City of Albuquerque Stormwater Construction Site Inspection Report

Project Name:	MJ Hospitality Self Storage		
Location:	4100 Yale		
Site Contact Name & Agency	Leo Rojas - ARFA Const. jasser007@gmail.com	ESC File No.	G16E095F
		NPDES Id. No.	NMR1000YT
Inspection Date:	12/05/19	Start/End Time:	0925/1015hrs
CoA Stormwater Inspector:	Timothy E. Sims		
Construction Phase:	vertical		
Type of Inspection:	<input type="checkbox"/> Regular	<input type="checkbox"/> Storm Event	<input type="checkbox"/> Post Storm Event >0.25" <input type="checkbox"/> 311/Complaint <input checked="" type="checkbox"/> Follow Up

## Reinforced Silt Fence

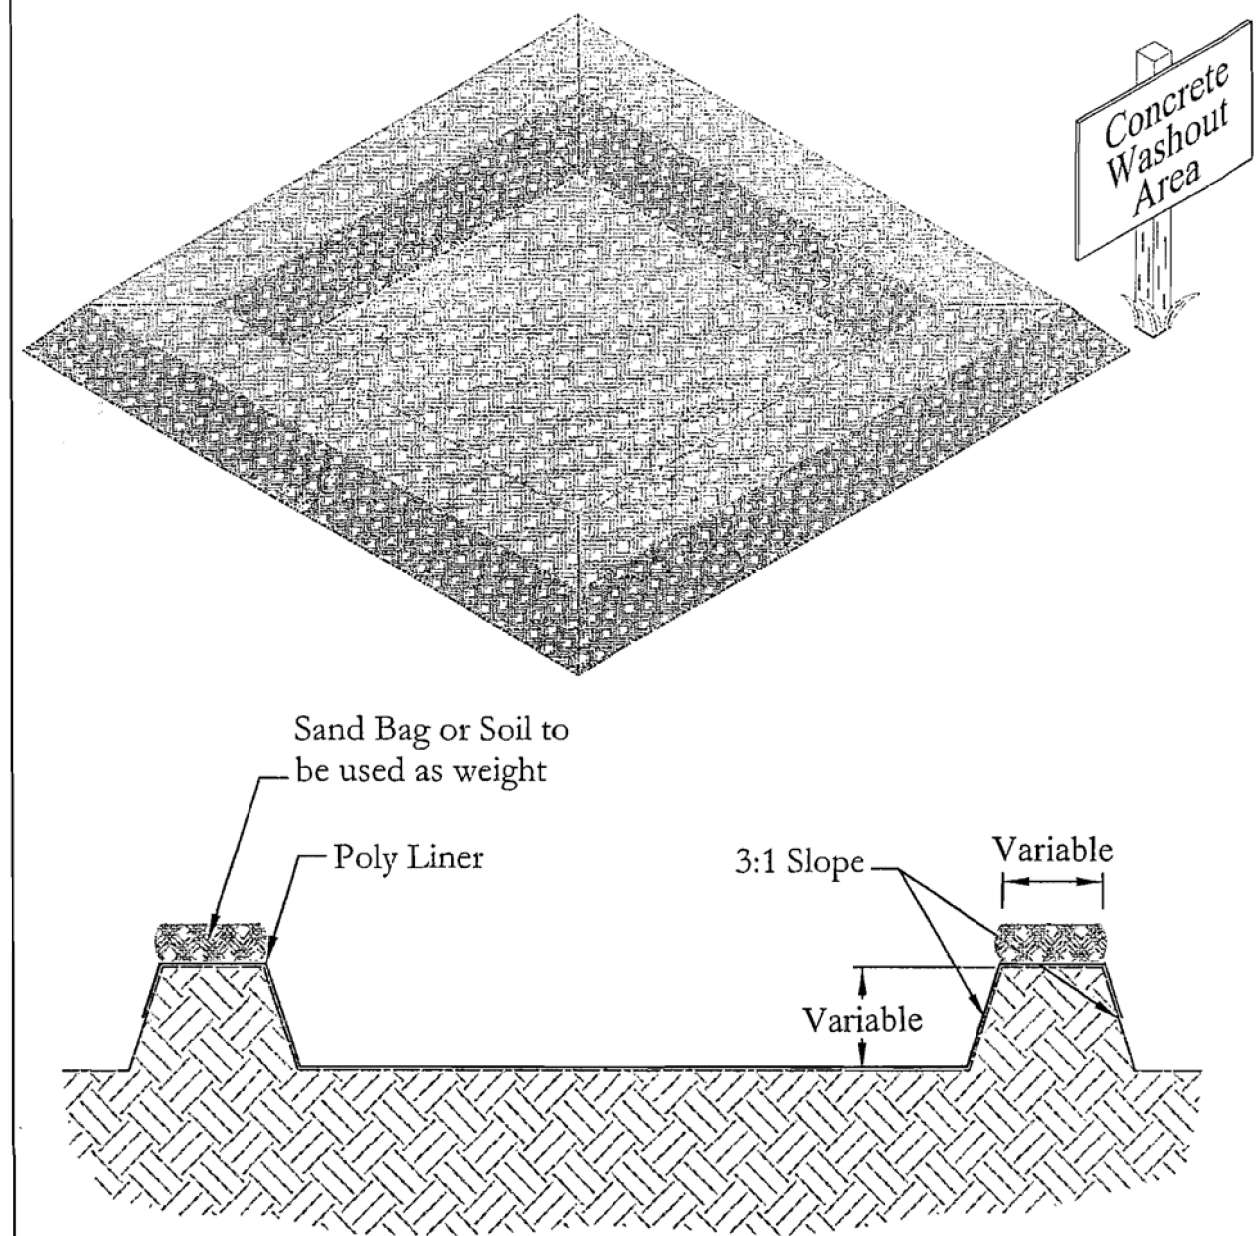
Item Number	Deficiency/ Corrective Action		
1***	Please mitigate west side of sites BMP. (either reinstall silt fence per plan detail or provide an equal BMP such as a mulch sock along western construction fence line)		
2	concrete washout facility requires maintenance. Please mitigate.		
3	Required reporting for an storm event is manditory after 0.25" of precipitation. On 11/27/2019 an event occurred. Provide SWPPP self-inspection report.		
***	E-mail form Tim Ott requested a follow up inspection. Site photos show silt fence not installed correctly; mulch sock does not extend southward enough to provide adequate protection. The new silt fence on the northwest, (at port-a-let to pond) is not installed correctly.		
2.1	Discharge off site? (Y/N)	No	
4	Self Inspection Reports	requested	Latest report Date: 11/8/2019
